**CITY OF ALBUQUERQUE
PLANNING DEPARTMENT**

January 29, 2014

DRB Comments

RE: Tracts 127 & 130 MRGCD Map #35

PLAT OF  
 LOTS A & B  
 LANDS OF JOSH ROMERO  
 PROJECTED SECTION 12, T. 10 N., R. 2 E., N.M.P.M.  
 ALBUQUERQUE GRANT  
 CITY OF ALBUQUERQUE  
 BERNALILLO COUNTY, NEW MEXICO  
 MARCH 2009  
 SHEET 2 OF 2

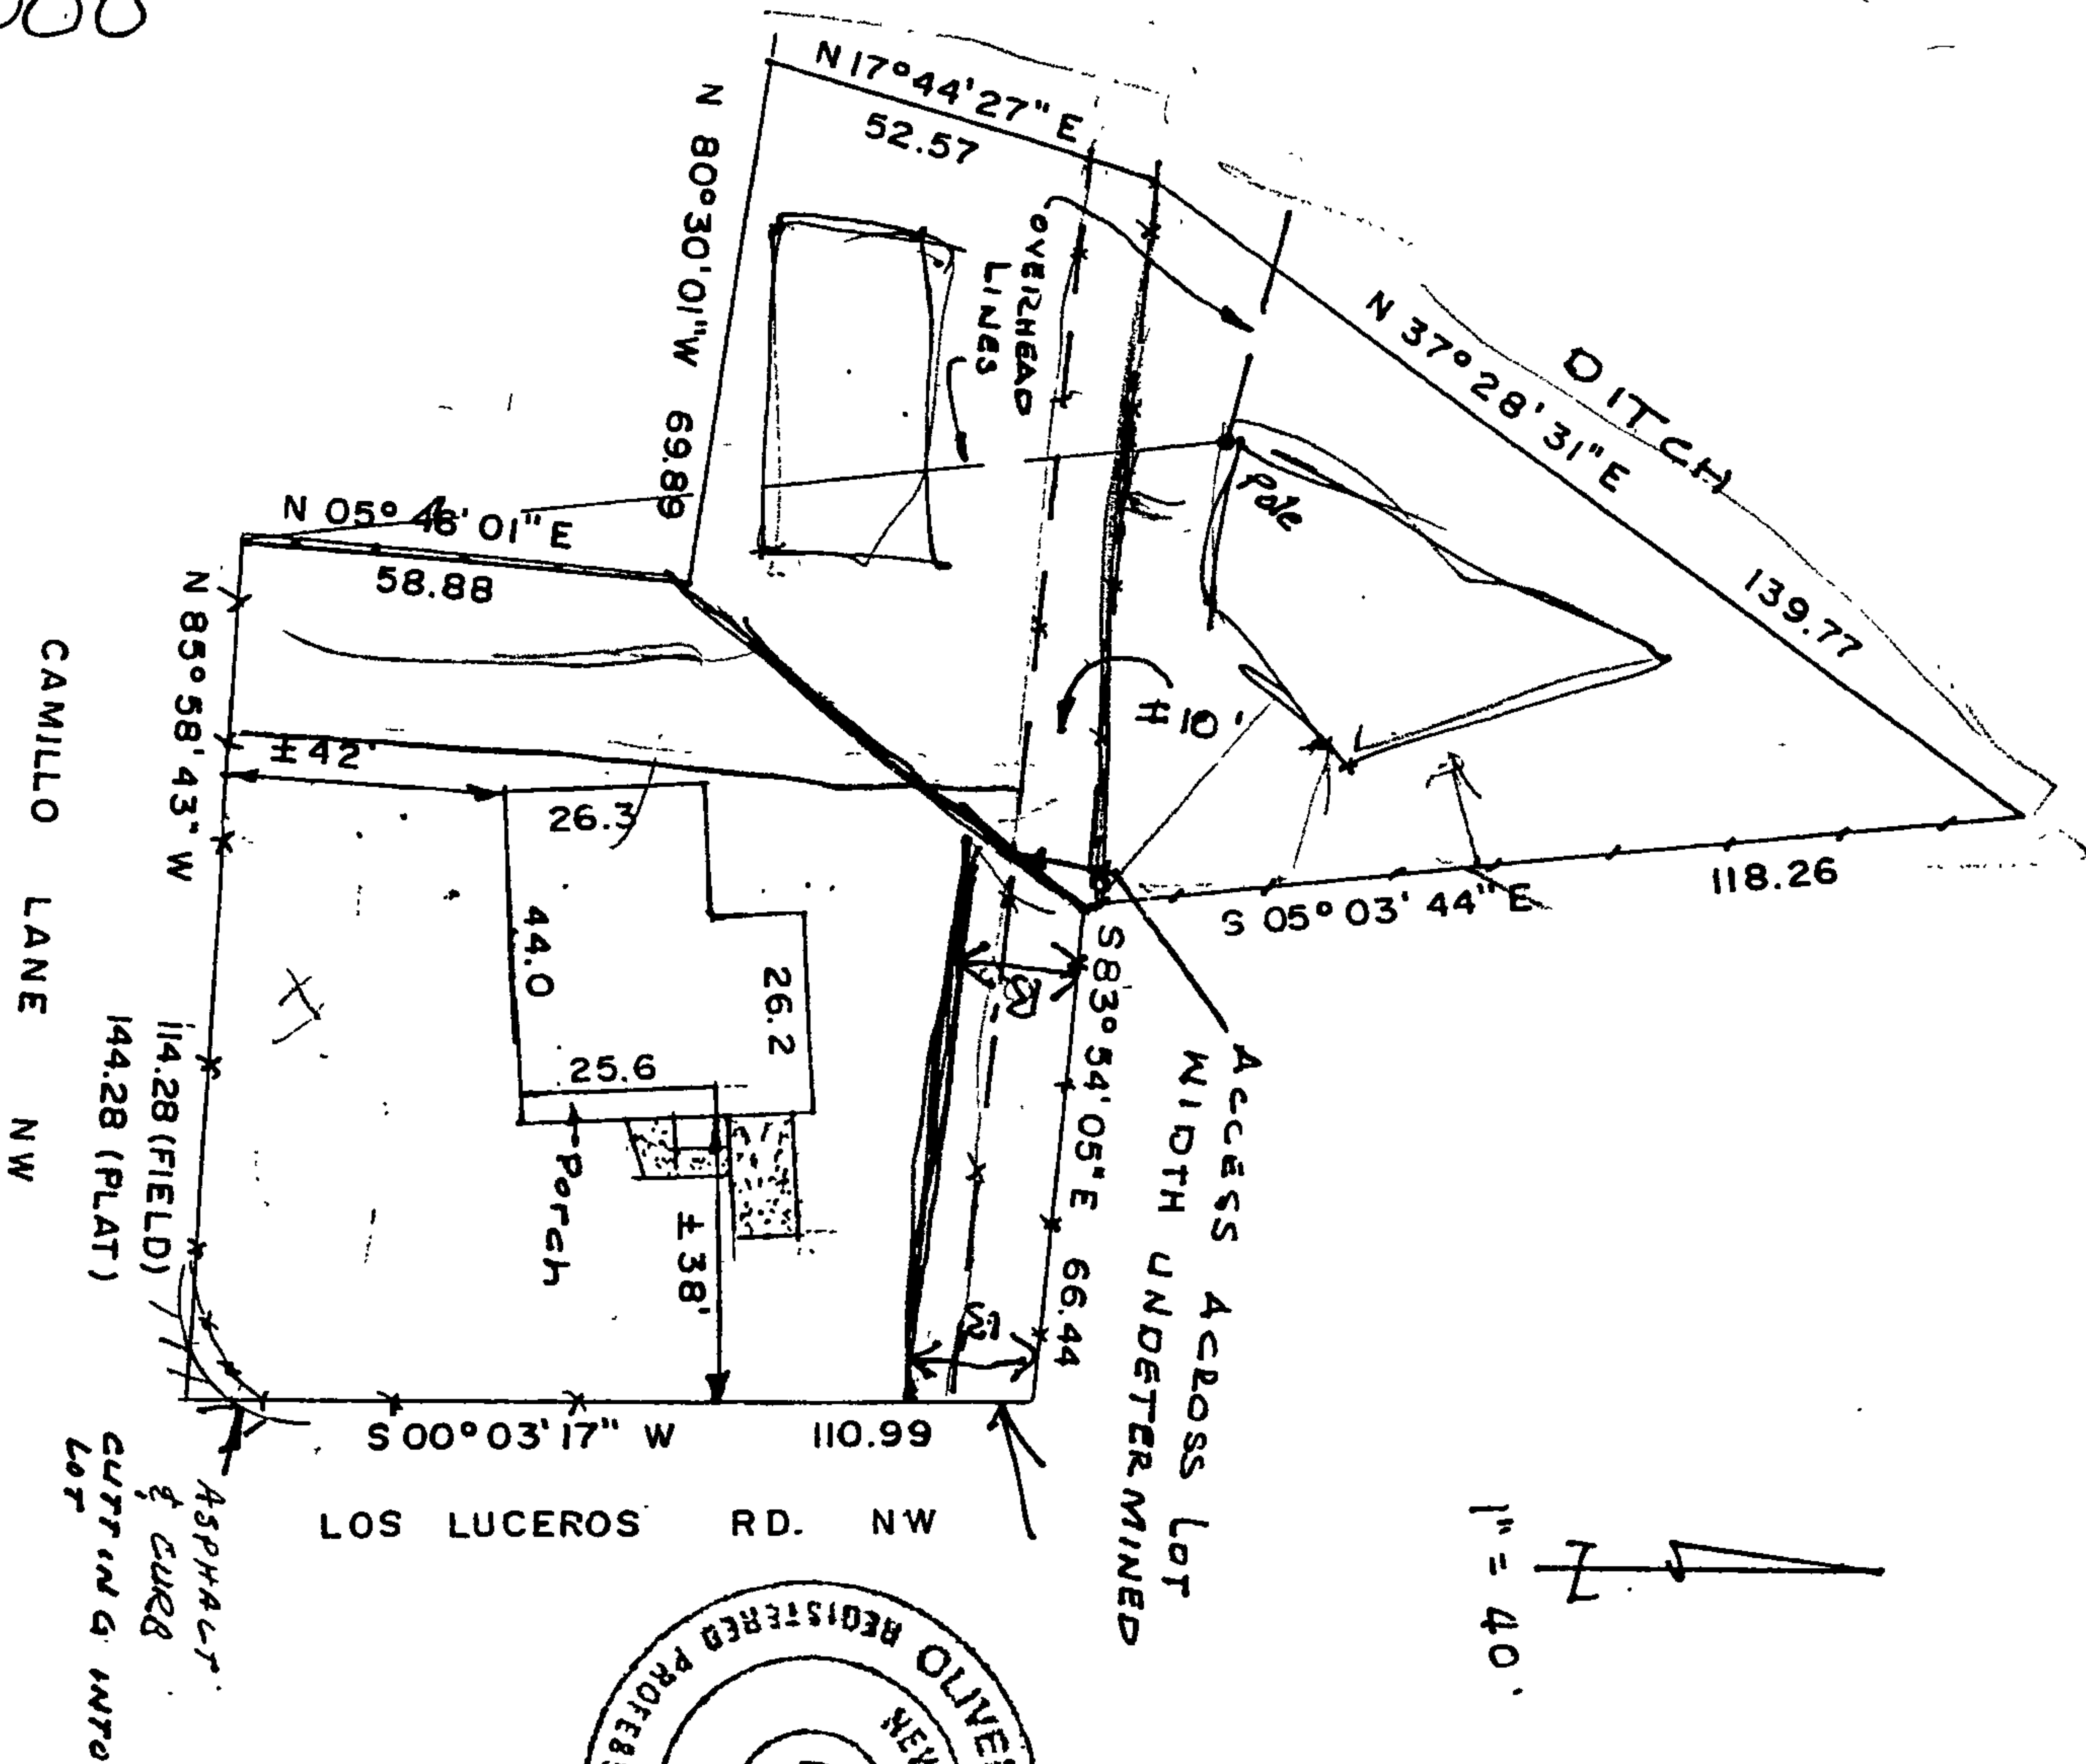
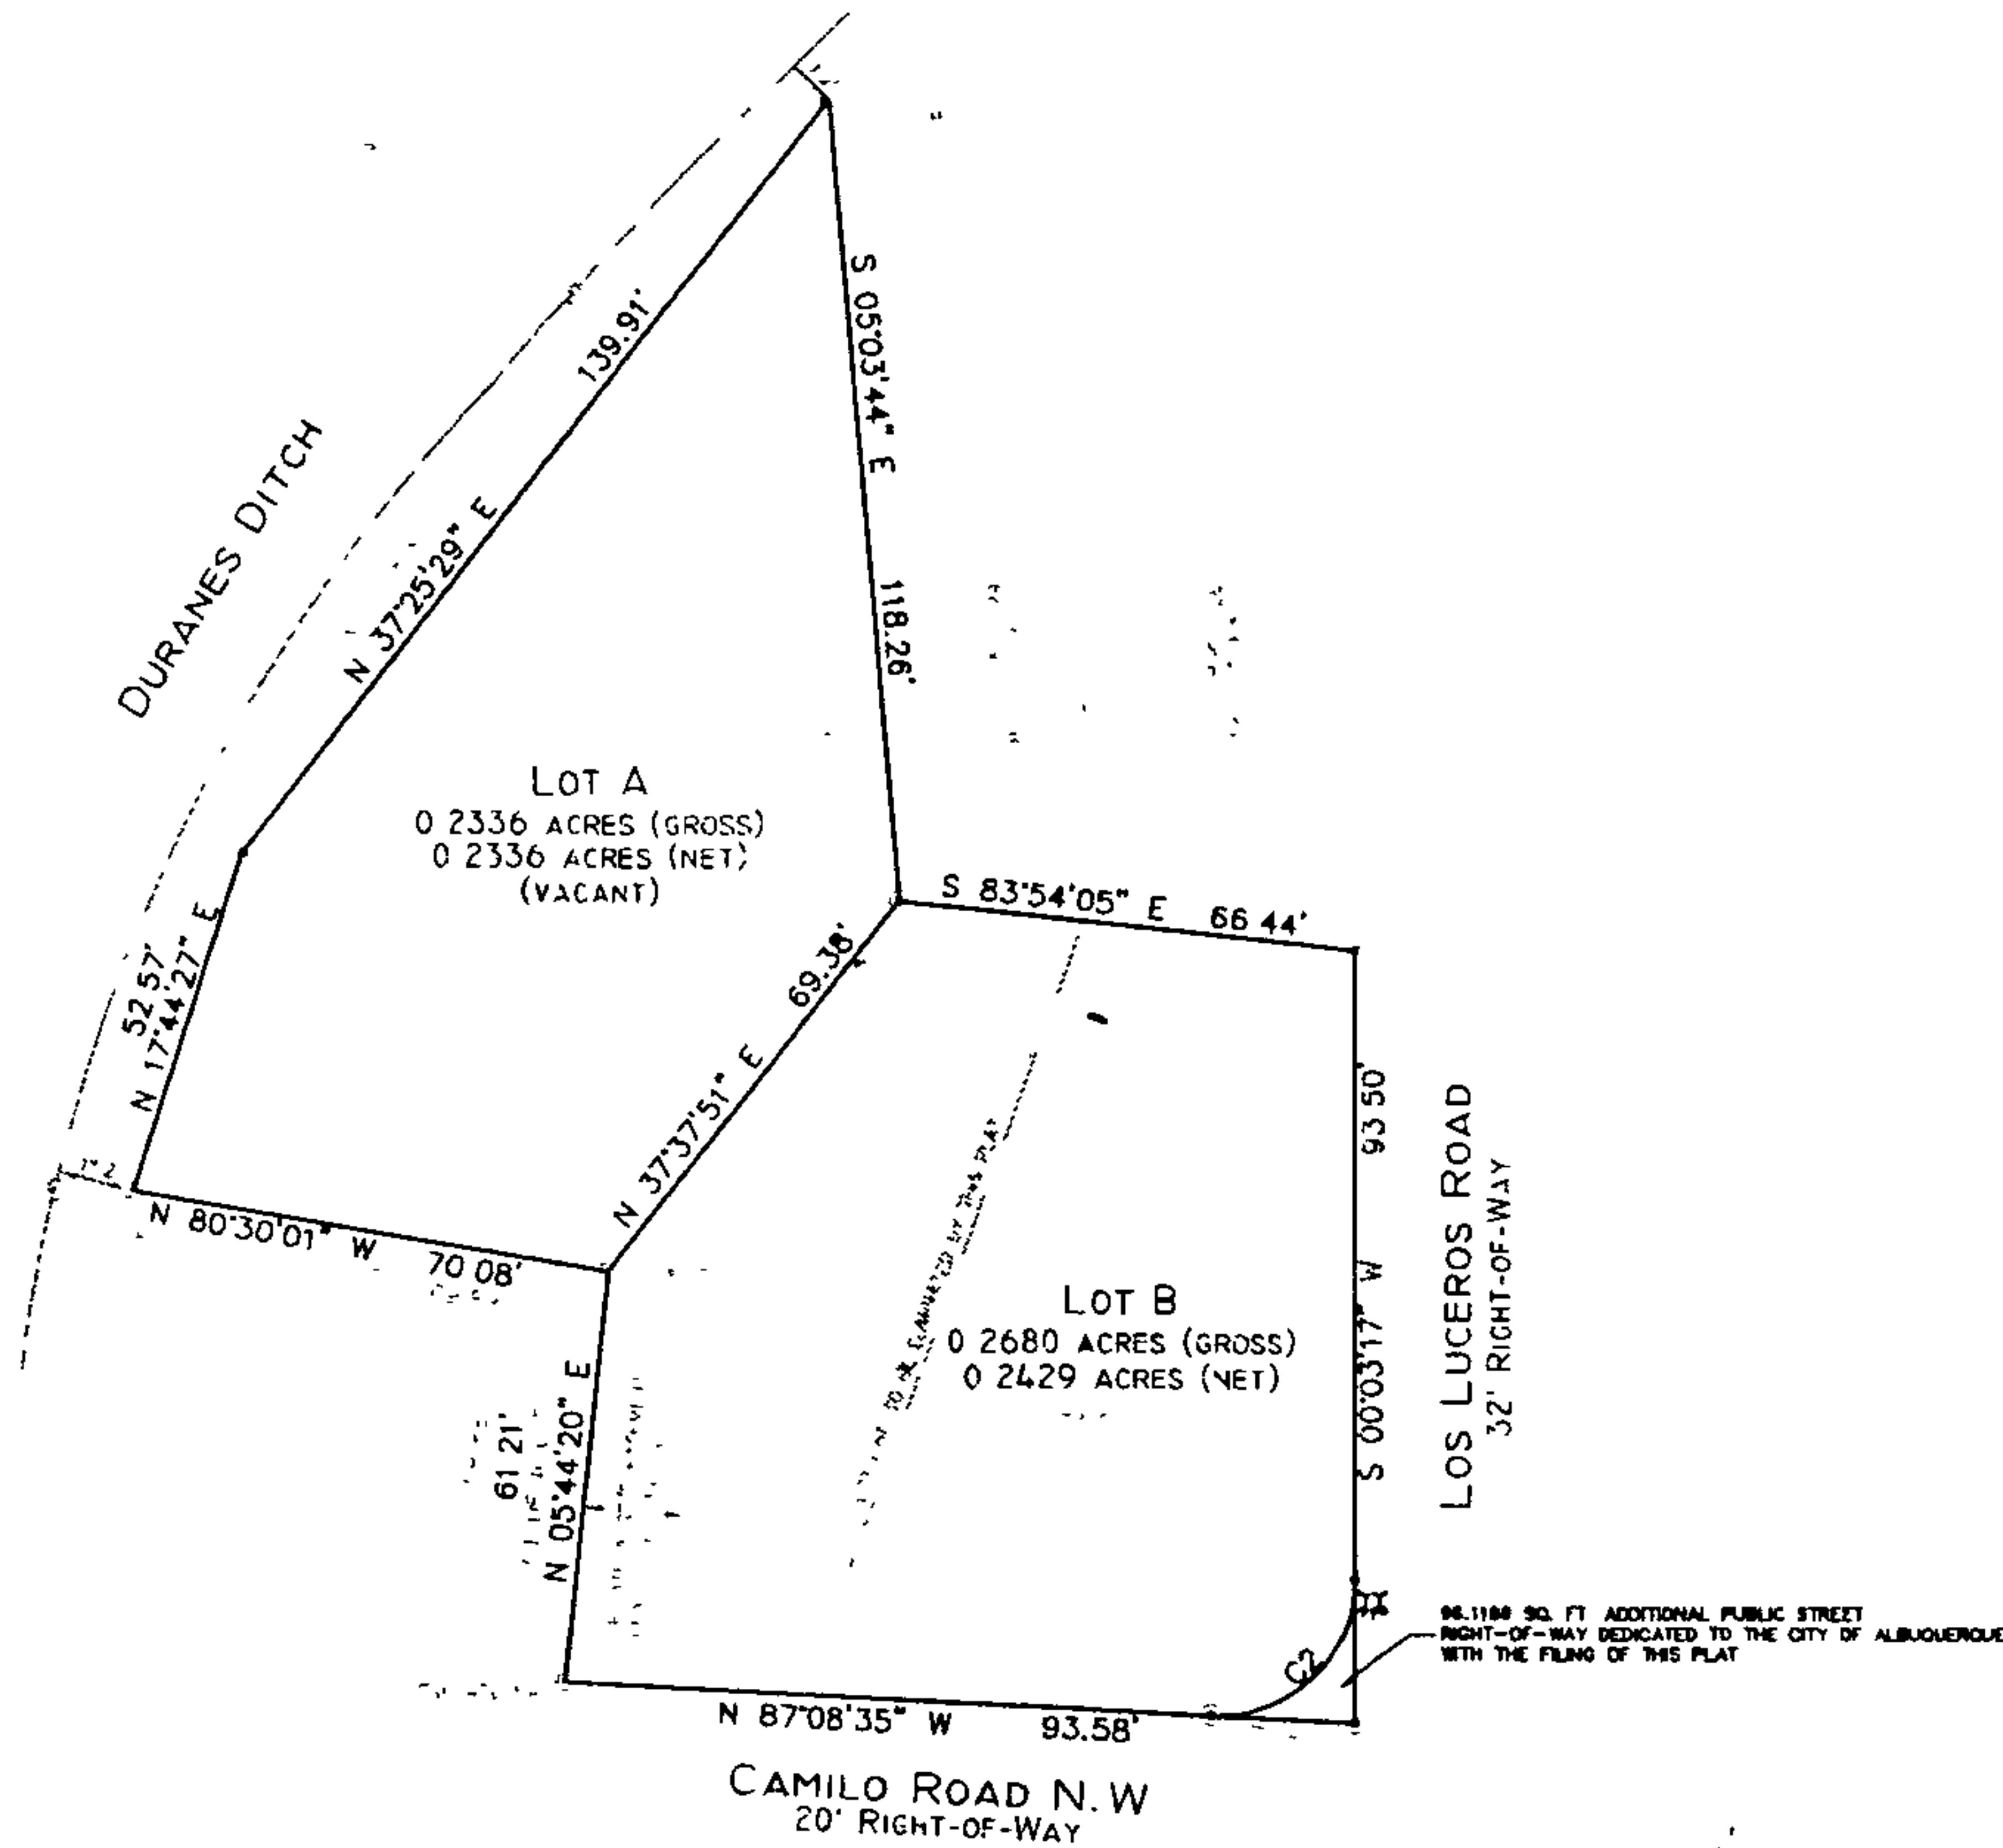
The minimum required easement off Los Luceros to provide private access and private utilities for 2903A Camillo LN and proposed rear lot is 22 feet; utilities might also be available from Camillo – refer to comments from ABCWUA.

It will need to be demonstrated that the proposed rear lot is buildable with a 22 foot easement running through the middle – it is recommended to contact Zoning Enforcement regarding required setbacks and how large a building footprint is possible.
